City of Portland, Maine - Building or Use Permit Application
 389 Congress Street, 04101 Tel: (207) 874-8703, Fax: (207) 874-8716

Permit No: 04-1545	Issue Date:	CBL: 336 E070001
------------------------------	--------------------	----------------------------

Past Use: Single family home	Proposed Use: Single family home w/new 26'x26' 2 car garage w/ family room over	Permit Fee: \$516.00	Cost of Work: \$55,000.00	CEO District: 5
		FIRE DEPT: <input type="checkbox"/> Approved <input type="checkbox"/> Denied	INSPECTION: Use Group: Type

Proposed Project Description: Build new 26'x26' 2 car garage w/ family room over	Signature:	Signature:
PEDESTRIAN ACTIVITIES DISTRICT (P.A.D.)		
Action: <input type="checkbox"/> Approved <input type="checkbox"/> Approved w/Condition <input type="checkbox"/> Denied		
Signature:	Date:

**PLOT PLAN / SITE PLAN**  
 FOR PROPOSED 26' x 26'  
 1 1/2 STORY 2 CAR GARAGE  
 ADDITION w/ FULL DORMER -  
 AT 65 BUCA RUN

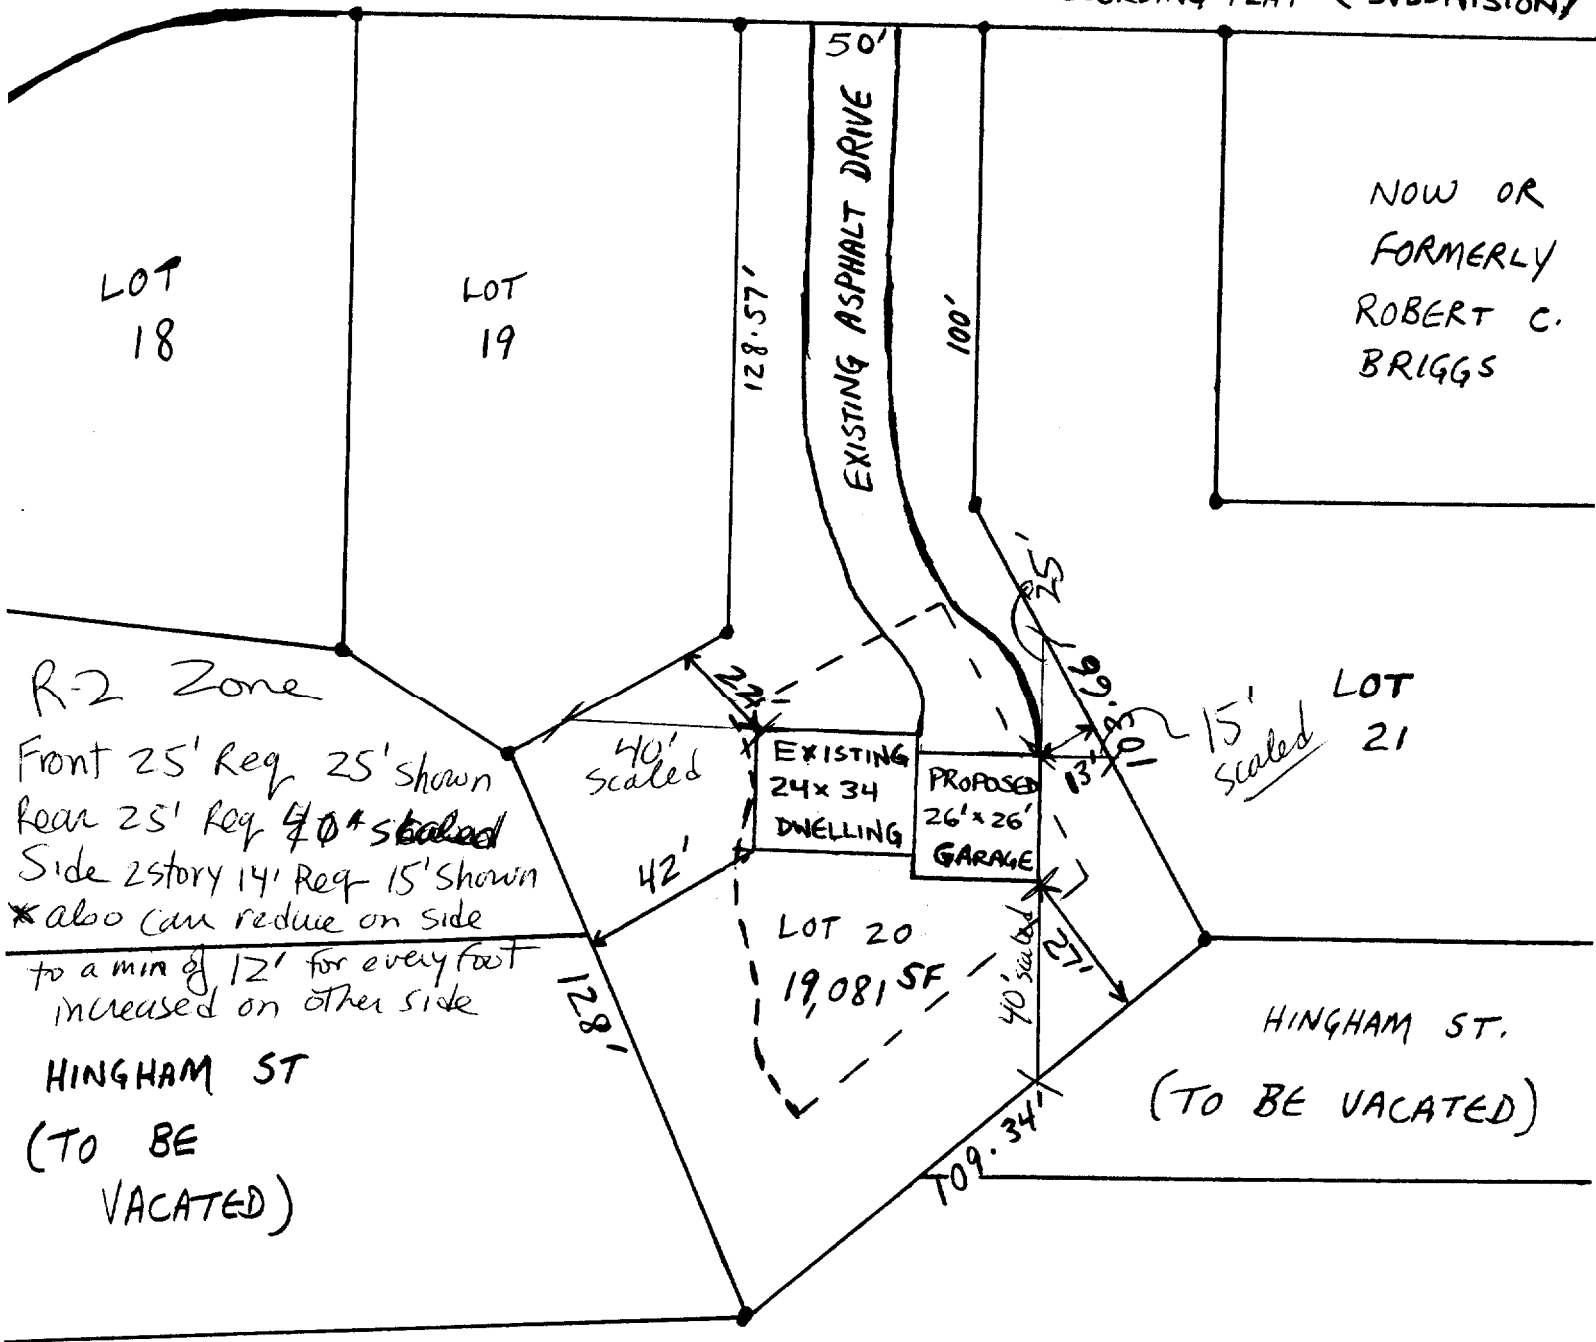
- 1) The full site plan review & fee for this garage was waived by this department and the DRC approved the site plan from the original subdivision with some minor changes.
- 2) As discussed w/Robert M., the front setback is very close to the 25' requirement. A survey may be required to verify compliance with the code.
- 3) This property shall remain a single family dwelling. Any change of use shall require a separate permit application for review and approval.
